PLANNING APPLICATION FORM - CONTINUATION SHEET

QUESTION 6. Condition(s) – Removal

Condition 2

Client:
Haycroft Homes Ltd
Proposed Houses
Plots 10 & 18 - 21

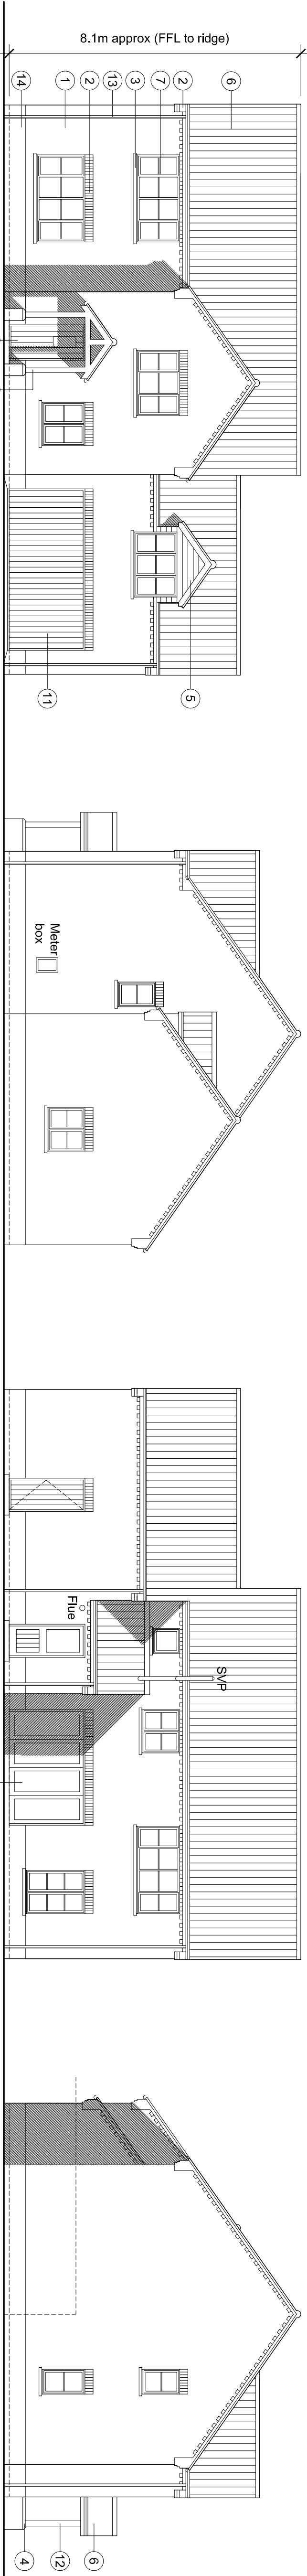
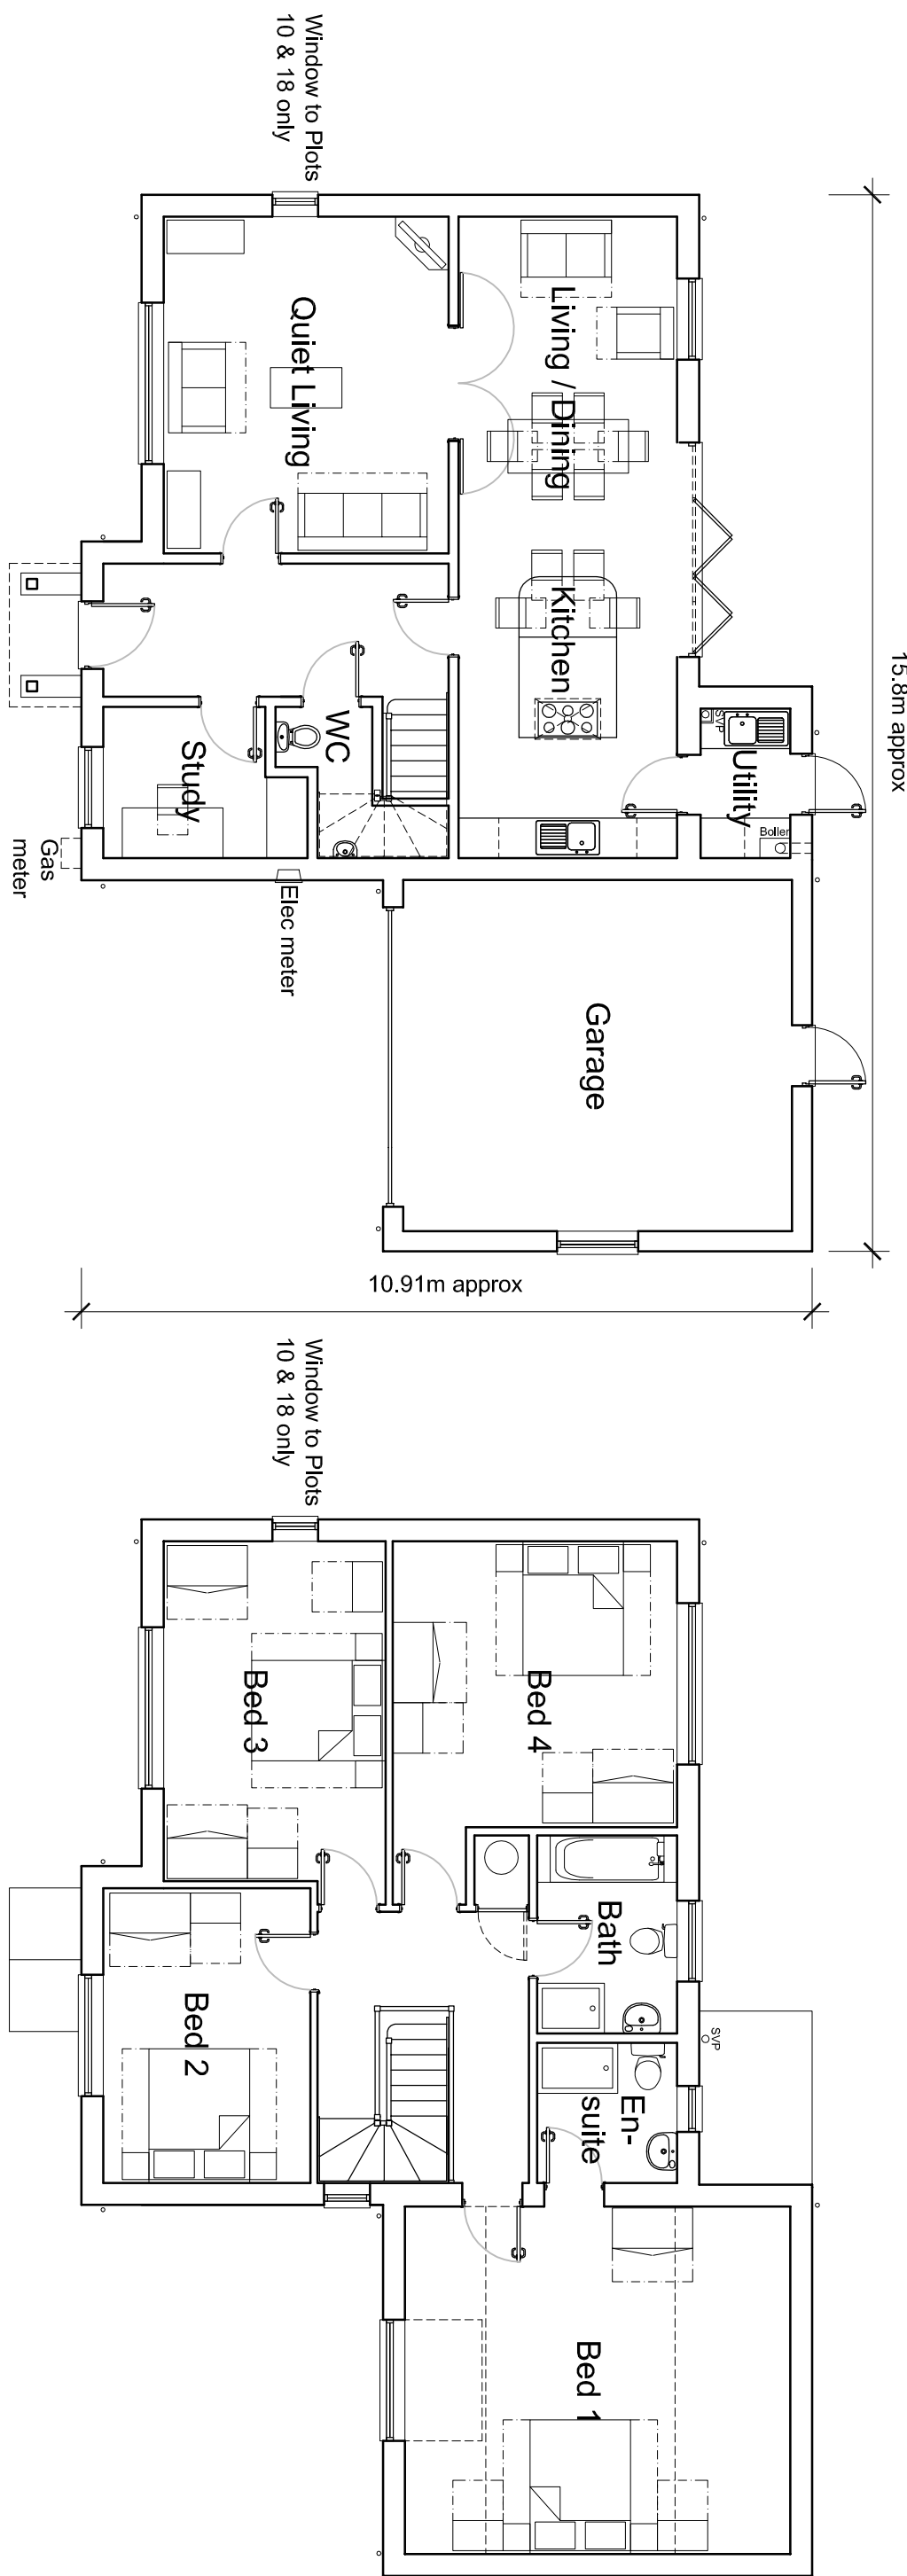
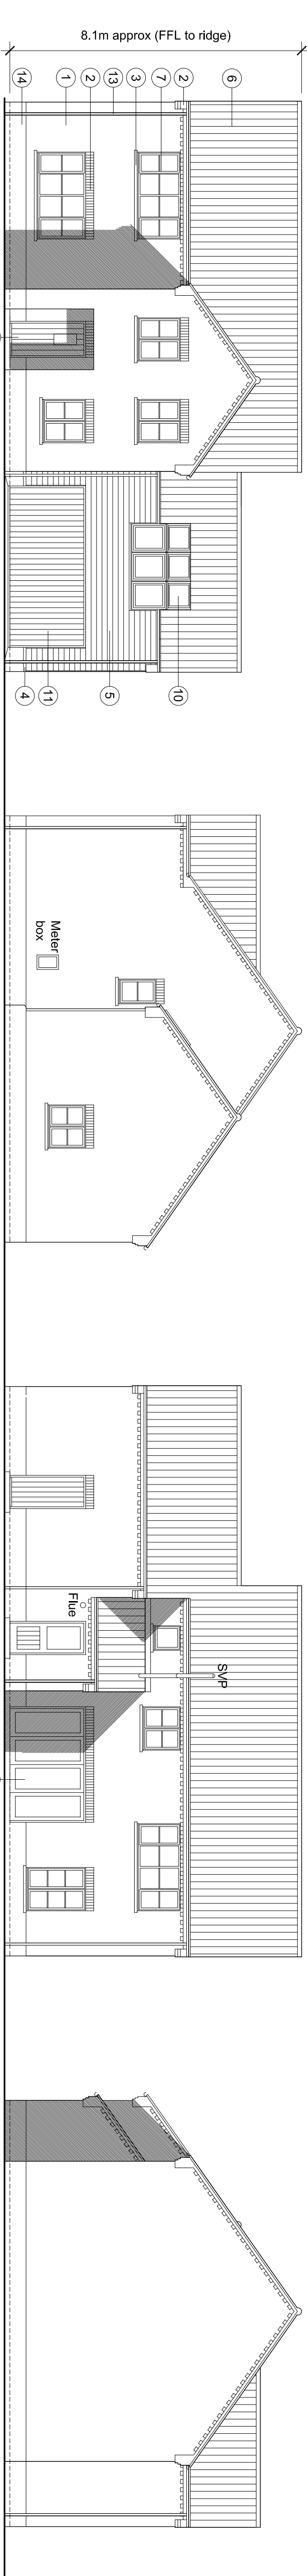
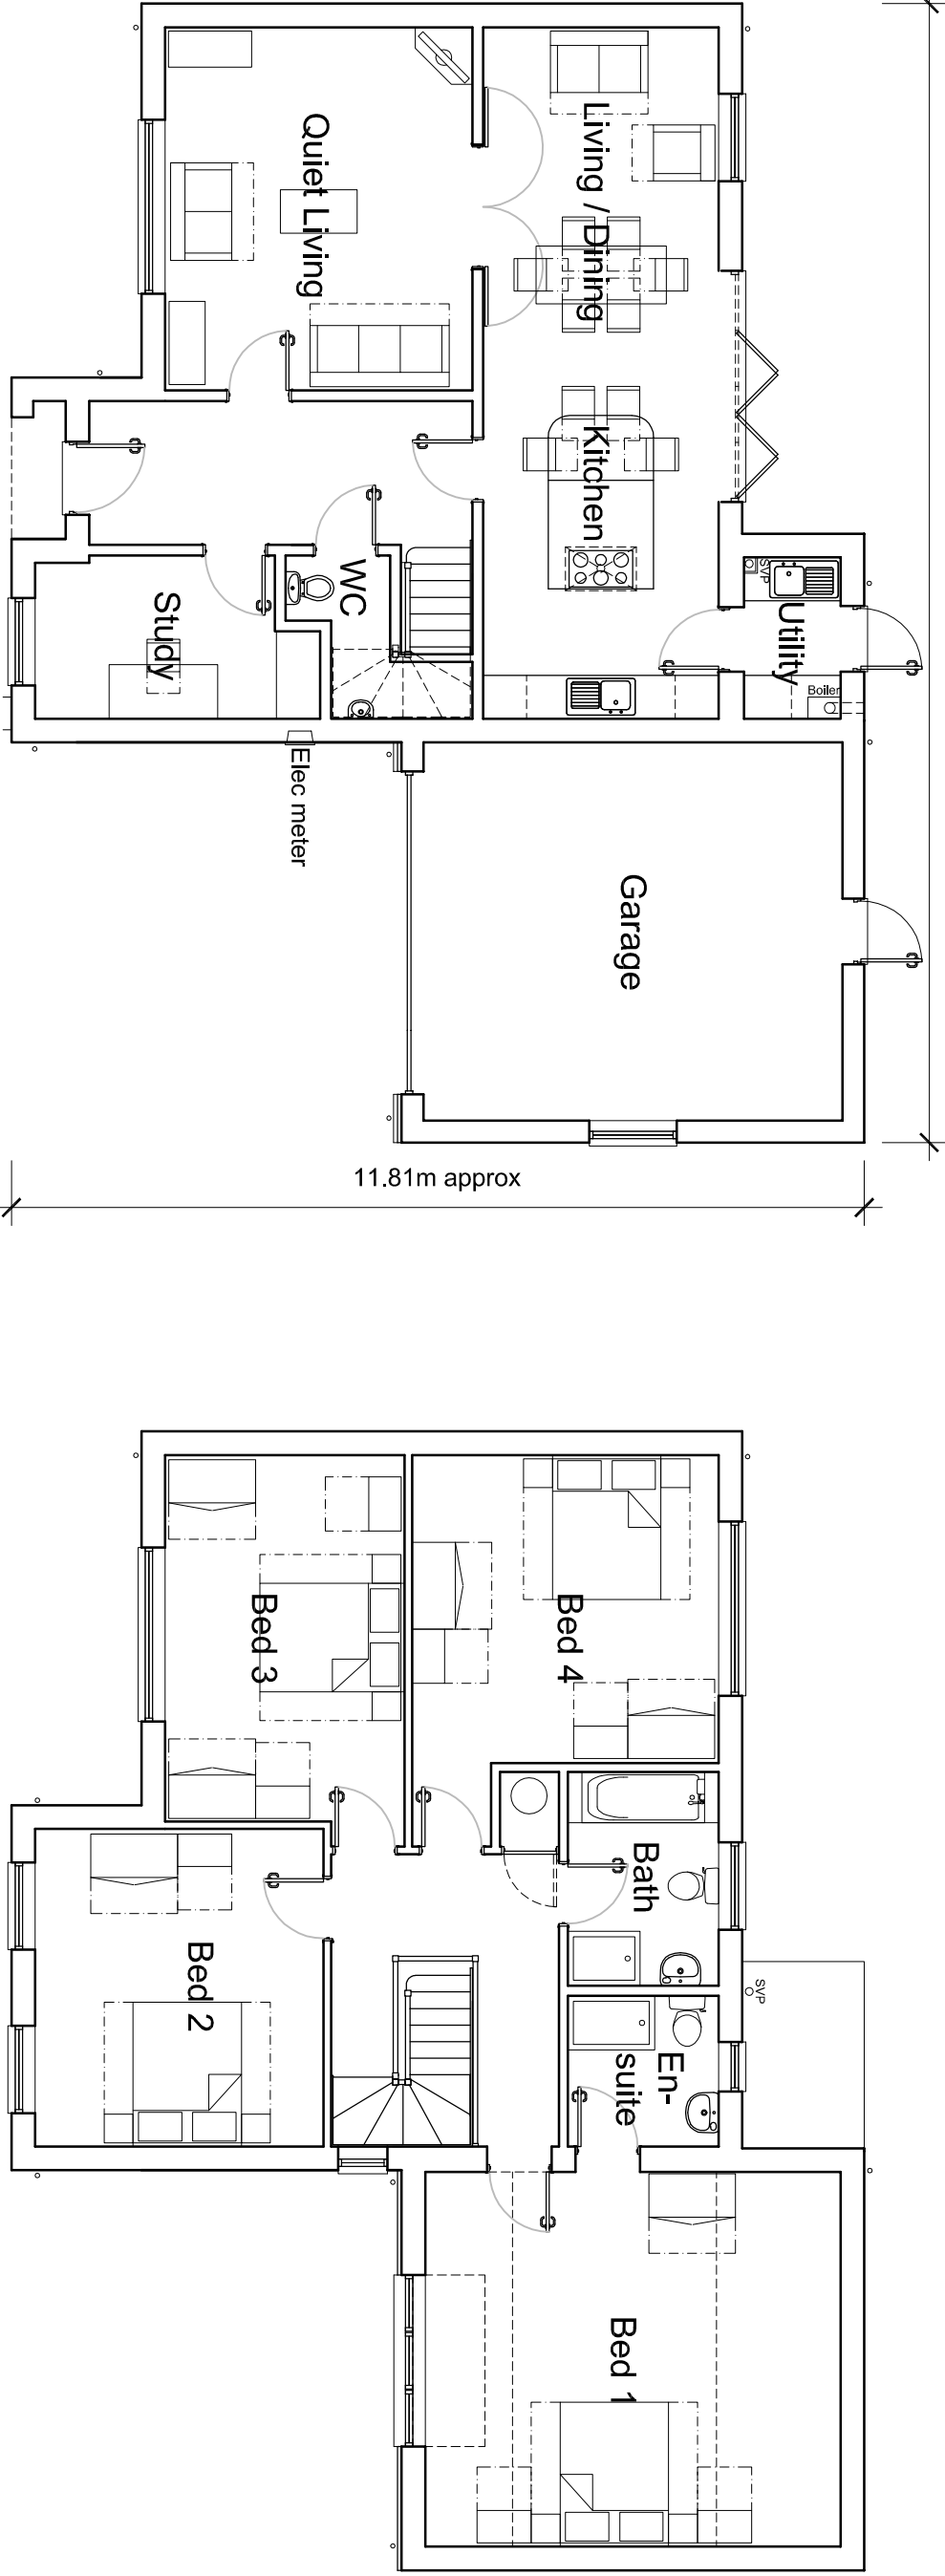
Widen properties to plots 10 & 18-21 to give larger rooms.

PD06, PD07, PD08, PD09, PD10 & PD11 are changed to show the addition of meter boxes, gas flues and soil vent pipes. In addition drawing PD08 is changed to show widened properties. In addition drawing PD11 is changed to show revision to plot 32 to be same bungalow type as plot 33.
